# CITY OF ALBUQUERQUE

**RE: Bella Vista Assisted Living  
13101 Constitution NE  
Request 30-Day Temporary C.O. – Accepted  
Engineers Stamp Date 5/14/15 (J22D067)  
Certification Dated: 10/13/16**

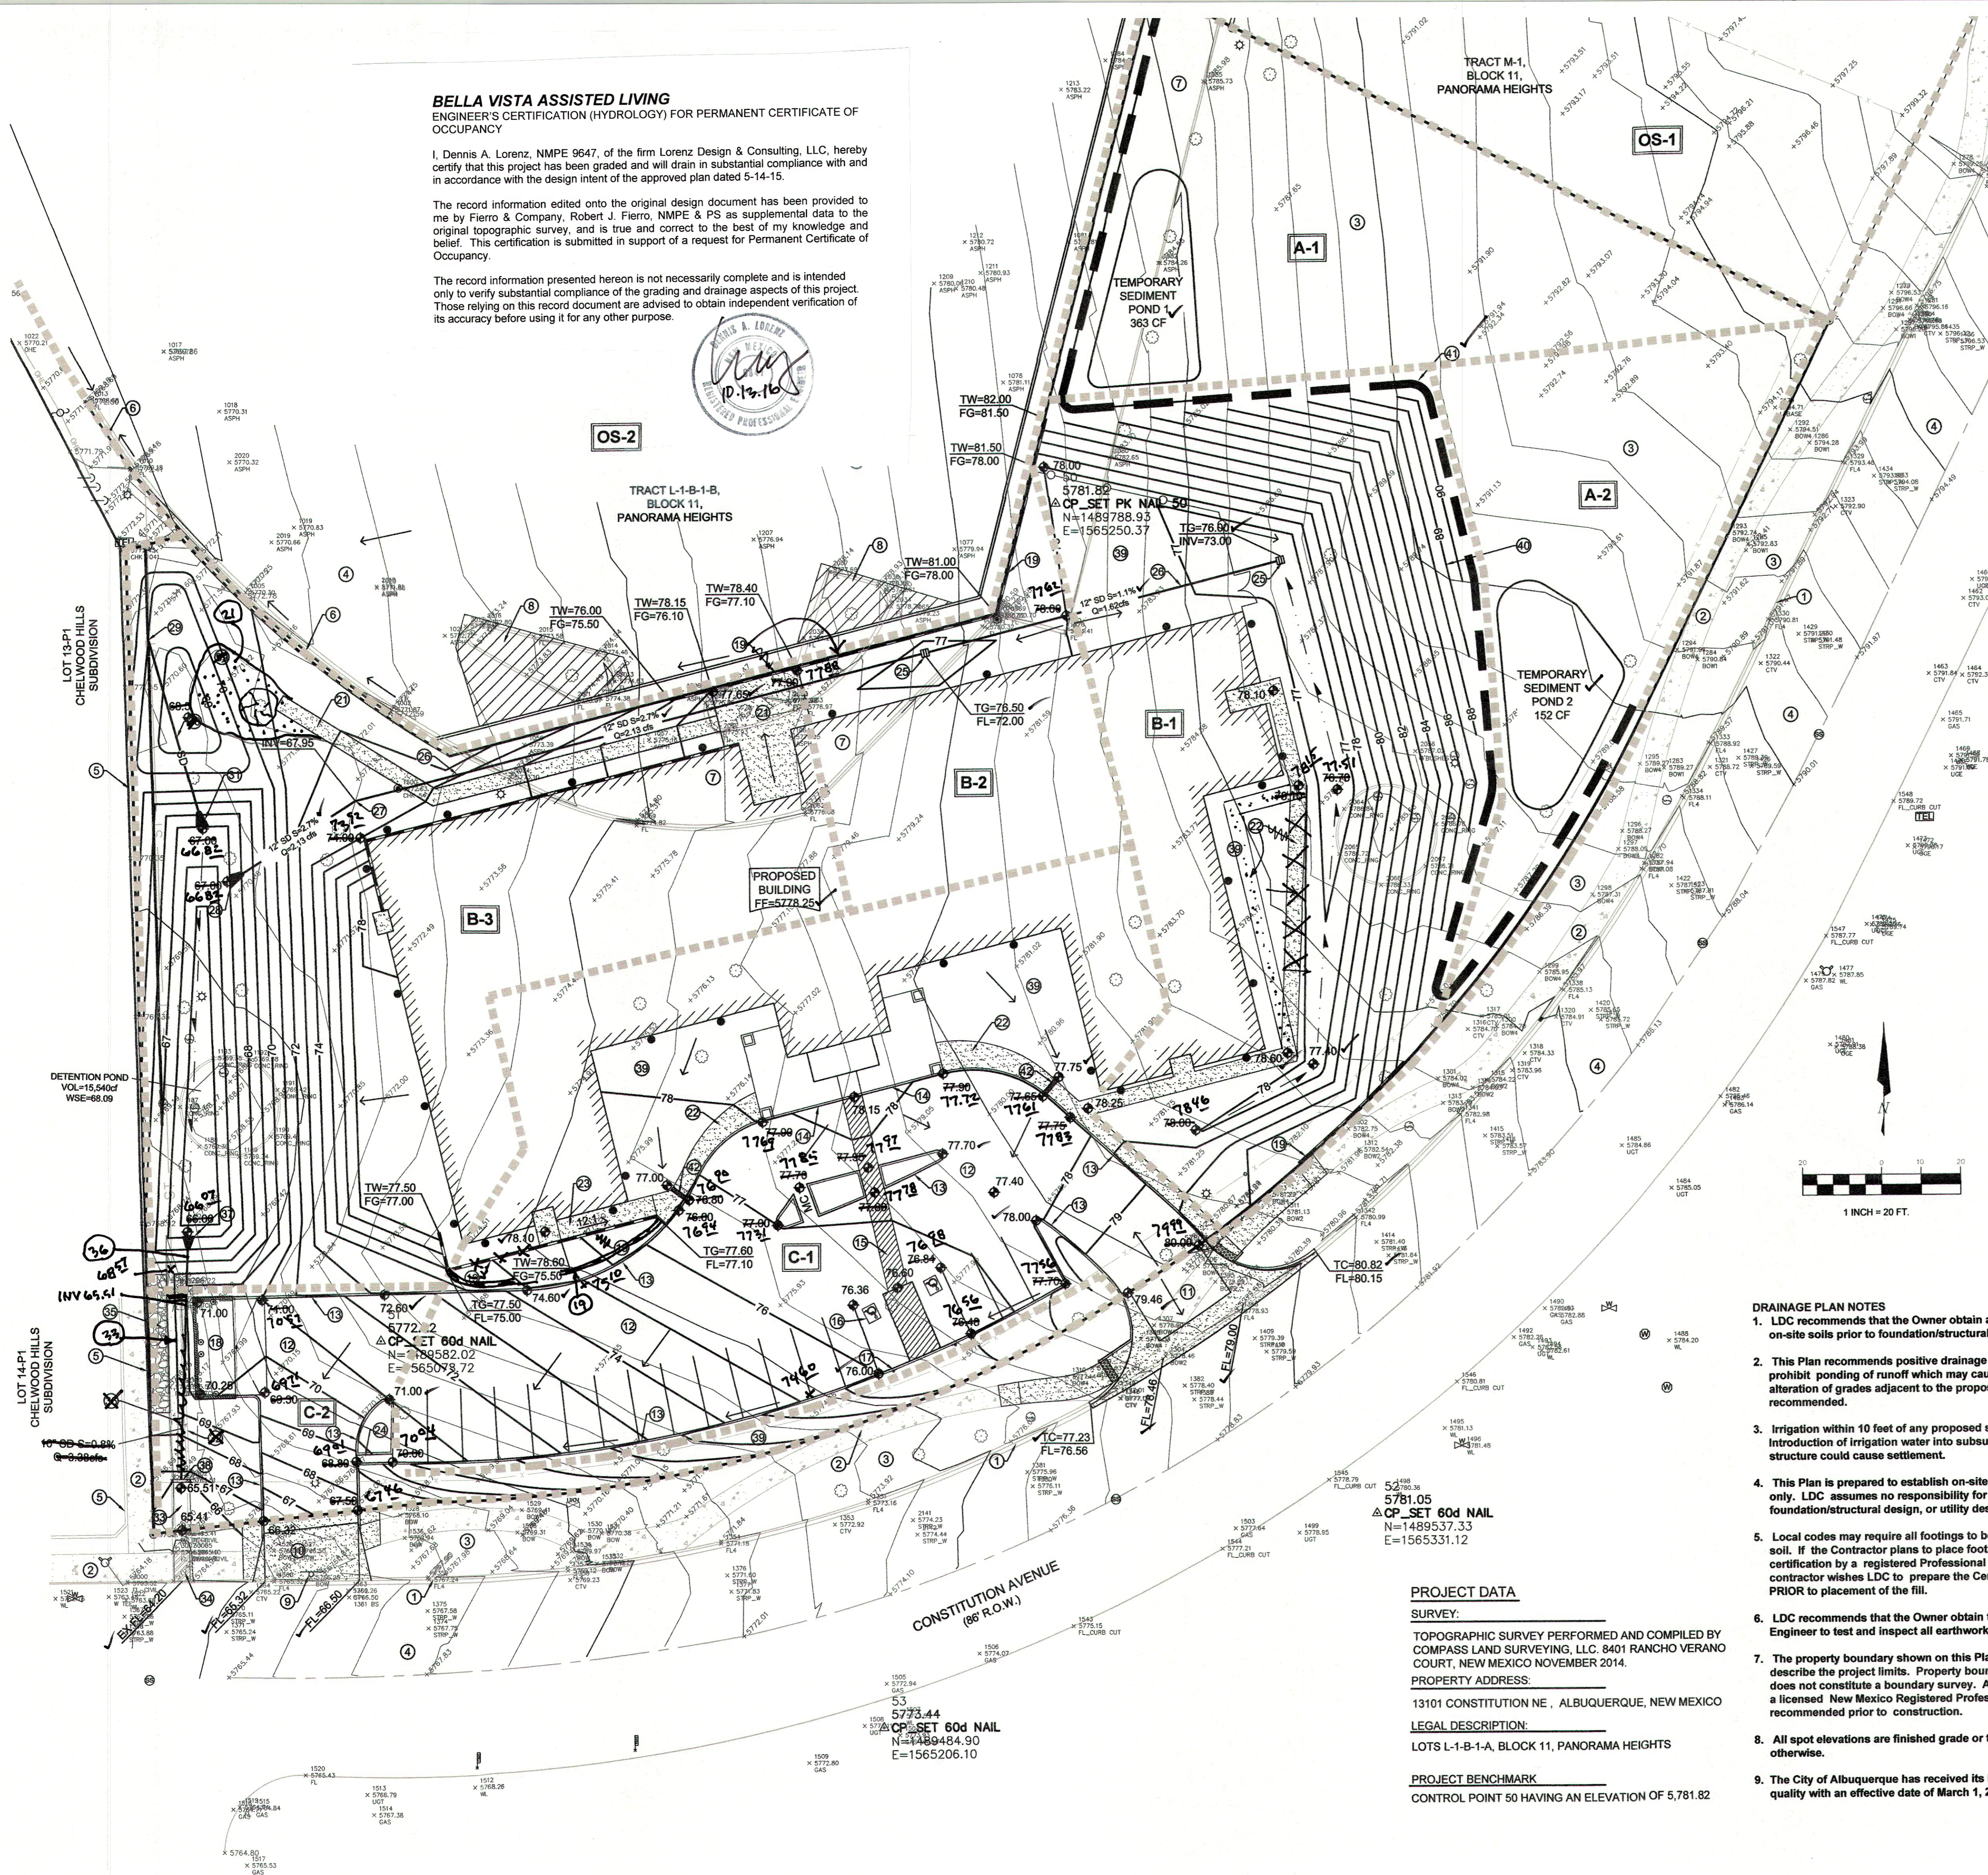
- On the east side of the building provide drainage to flow past sidewalk thru either a pipe underneath the sidewalk or a sidewalk culvert at 6 downspouts.
